## St Joseph's College Physical Education and Sports Precinct Project (PESPP) (SSD 8970)

### RESPONSE TO SUBMISSION

Prepared on behalf of St Joseph's College

13 May 2019 | 16037

6.2 Streetscape Scale and Setback

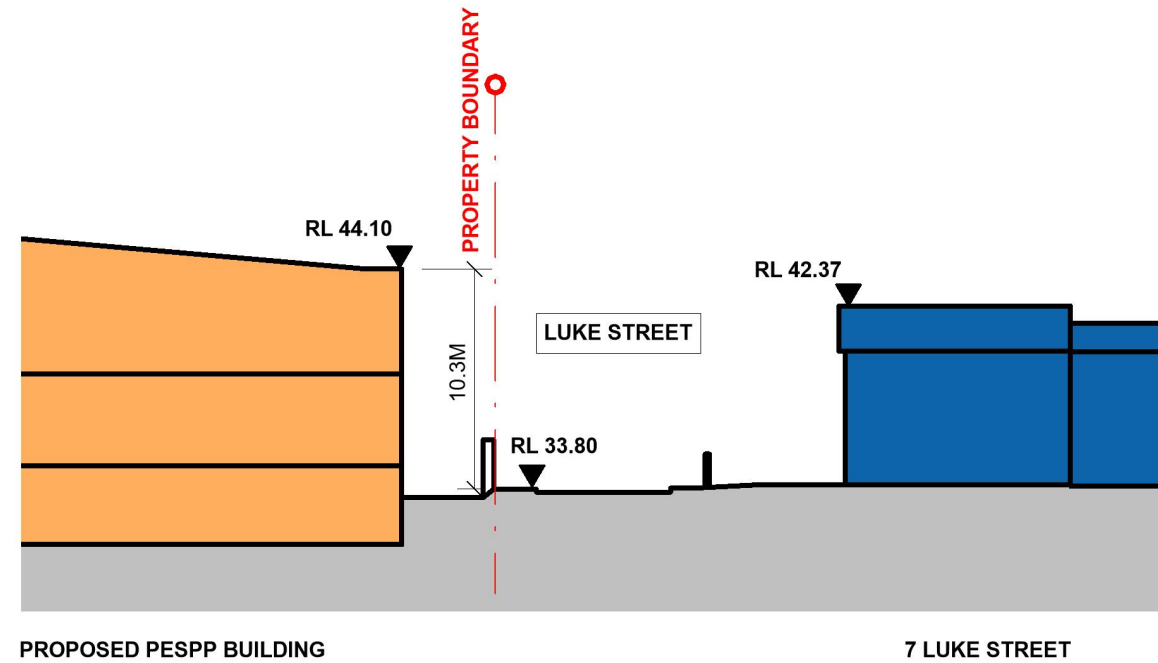
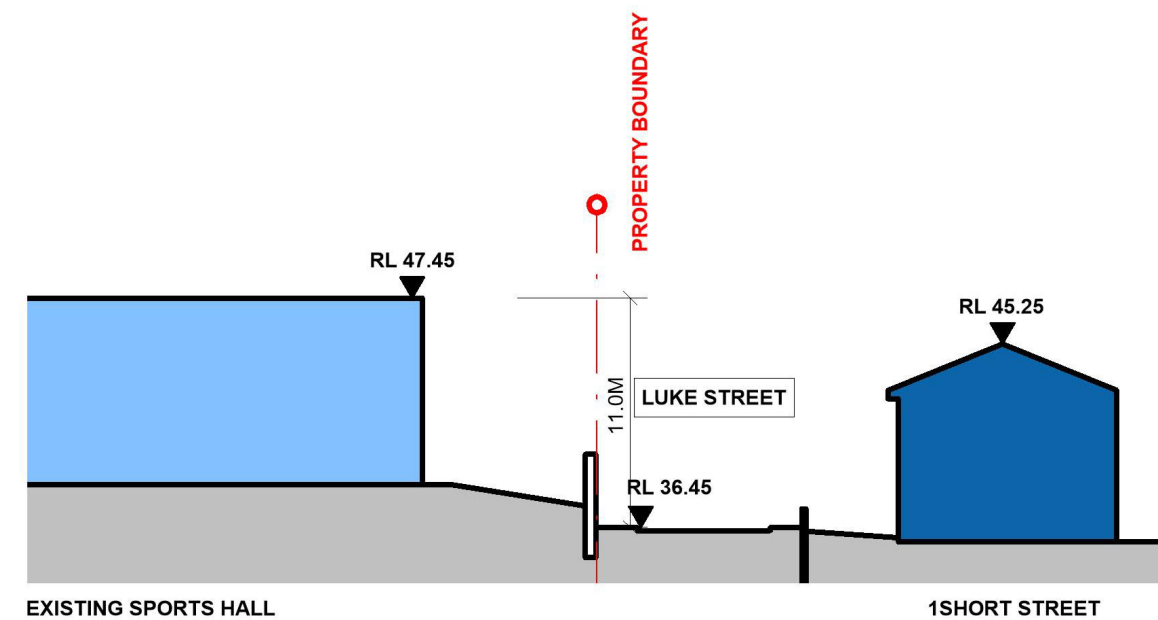
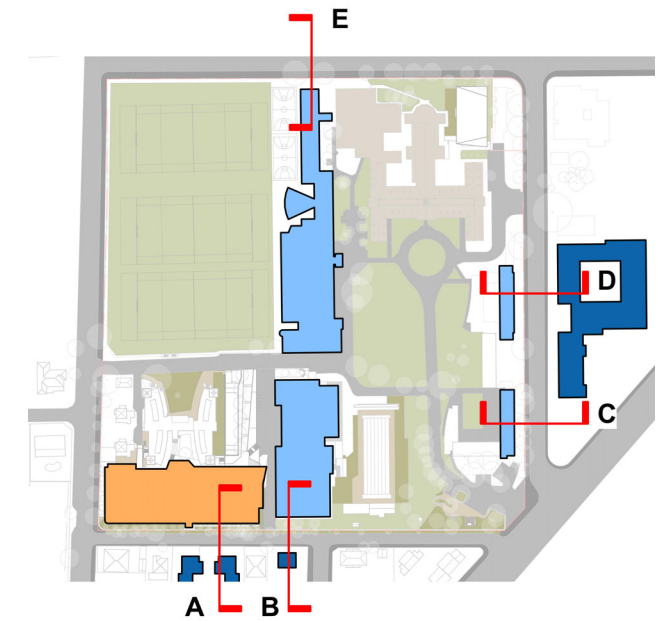
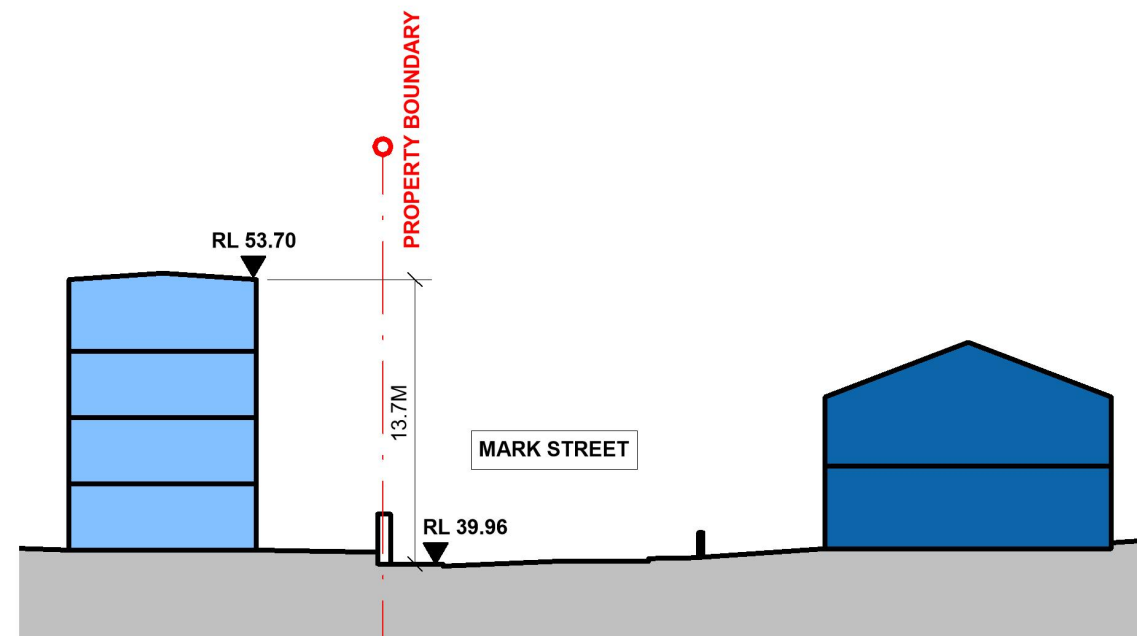
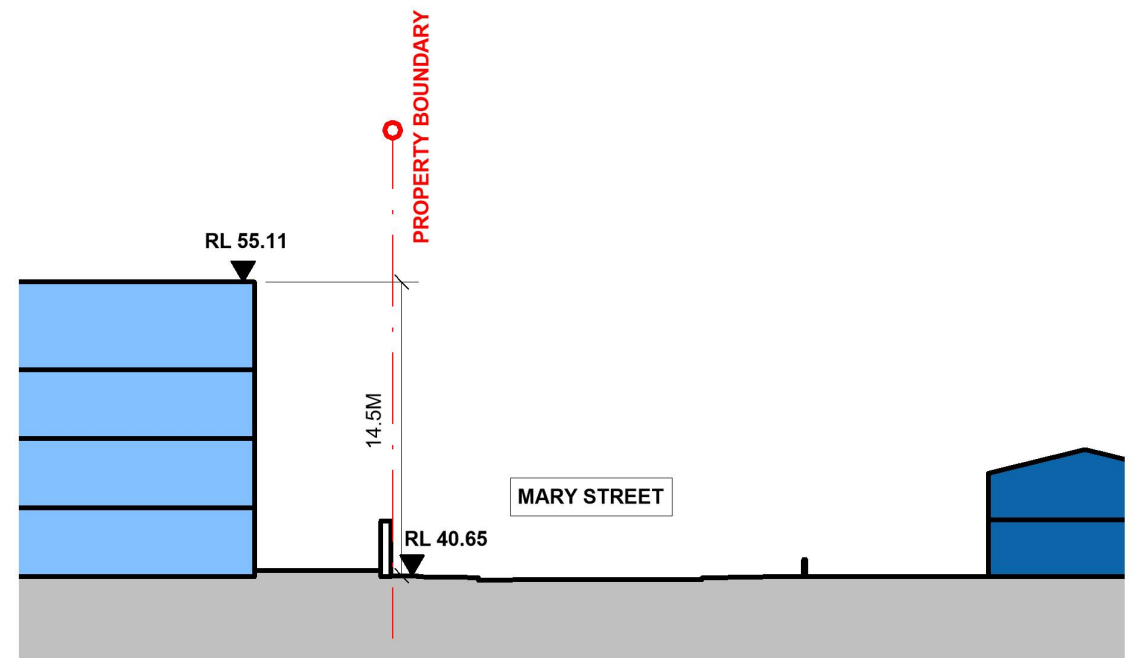
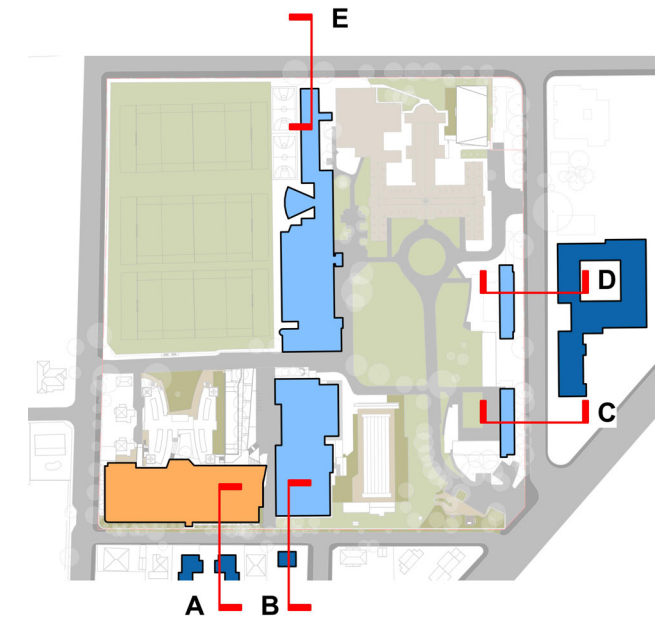
- *Additional photomontages, comparing the scale of the PSEP building with the existing buildings within the site and also in the locality (streetscape sections and overall site sections), must be provided to enable detailed assessment of the visual impacts of the bulk and scale of the proposed building*

VIEW FROM CORNER OF GLADESVILLE RD AND LUKE ST

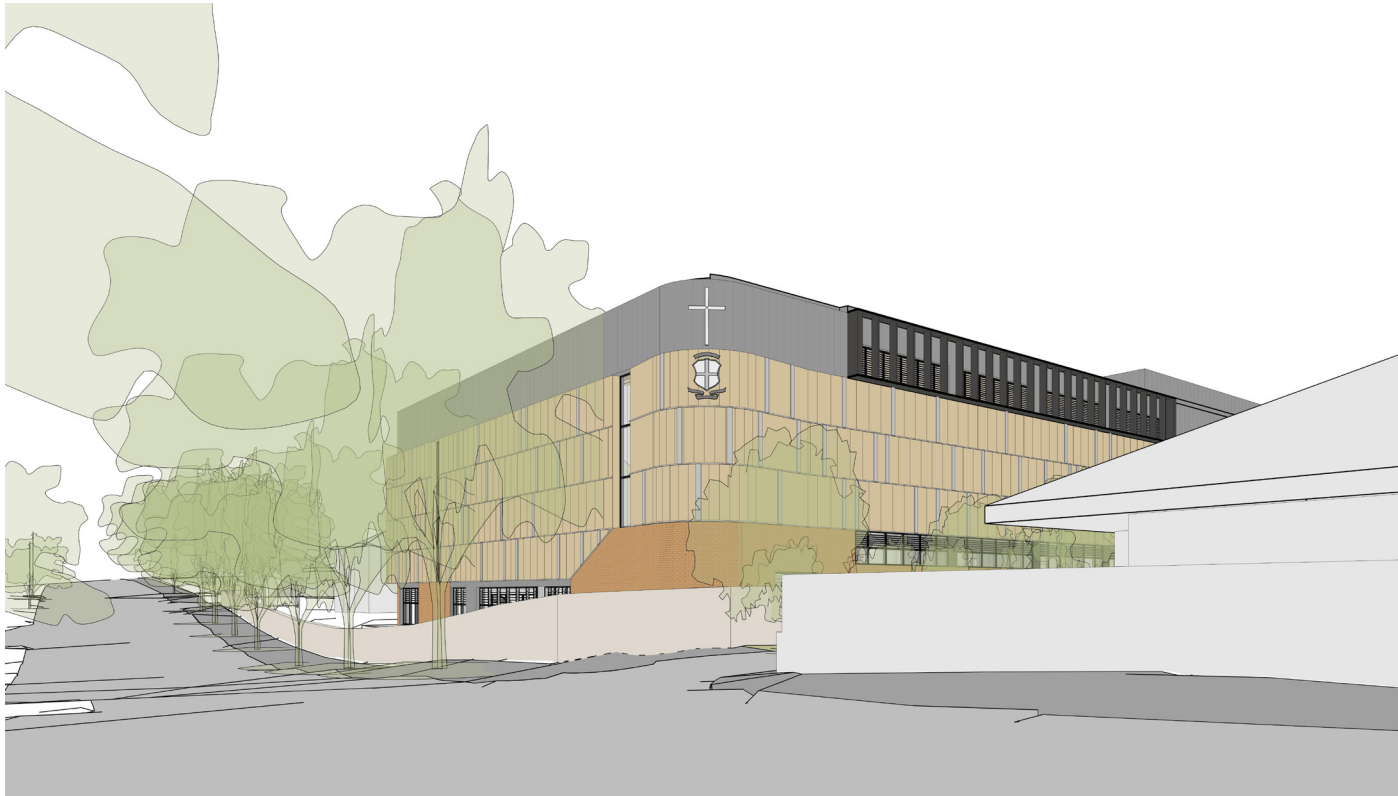
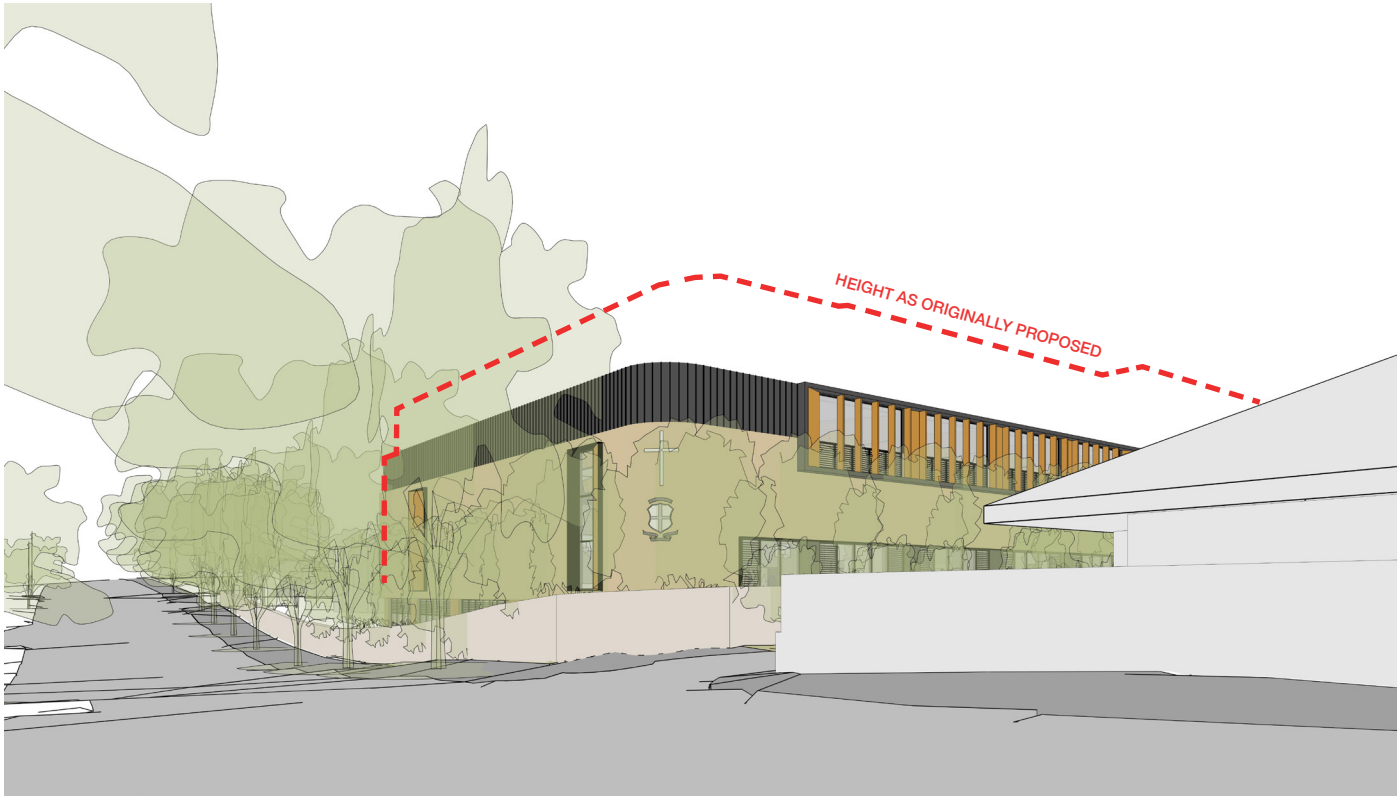
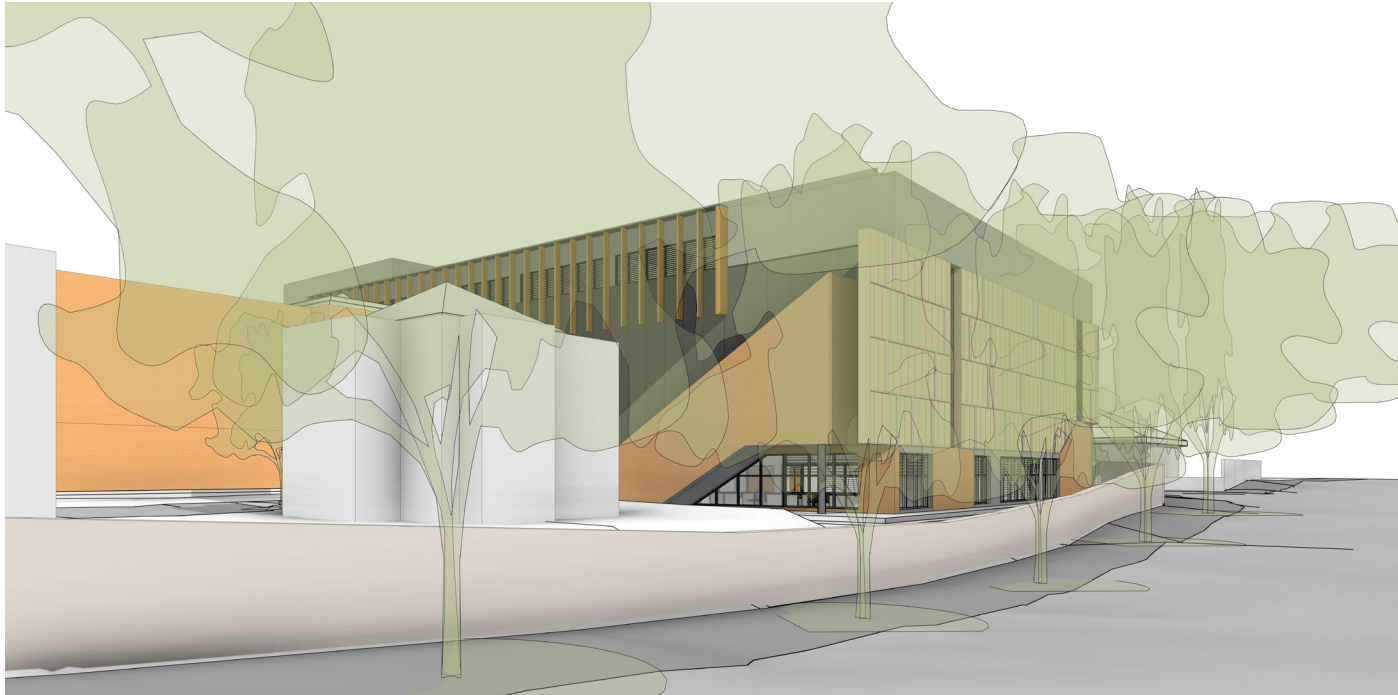
- *The Department considers that the proposed bulk and scale of the Physical Education and Sports Precinct (PESP) building is excessive and would not be compatible with the character of the immediately locality or the heritage values of the Hunters Hill Conservation Area No 1—The Peninsula. The bulk and scale of the PSEP building would dominate both street frontages due to its height and lack of setbacks to the boundary.*

- *The Department considers that opportunities to reduce the mass of the PSEP building and increasing the setbacks of the building from the site boundaries, must be explored. These may include additional excavation (to reduce the overall height), deleting components of the building on the upper level such as meeting rooms and / or reducing the overall building footprint.*

1. **Luke Street Setback:** A 4.3m building setback to Luke Street is proposed (compared with 1.3m in the Original SSDA). The proposed setback allows the majority of trees on Luke Street and Gladesville Road to be retained (approximately existing 20 trees) and provides for the planting of 21 new trees within a landscape buffer located between the PESPP and stone wall. The increased setback also simplifies the required construction solution to protect the stone wall.

2. **Building height:** A 2.7m reduction in the height of the parapet and ridge of the main roof is proposed (-19%). This is achieved by increasing the excavation depth to lower the entire building and relocating the roof plant away from Luke Street. The amended *building height* of the parapet and ridge, which varies along Luke Street and Gladesville Road, is predominantly 11.4m compared with 14.1m in the Original SSDA.
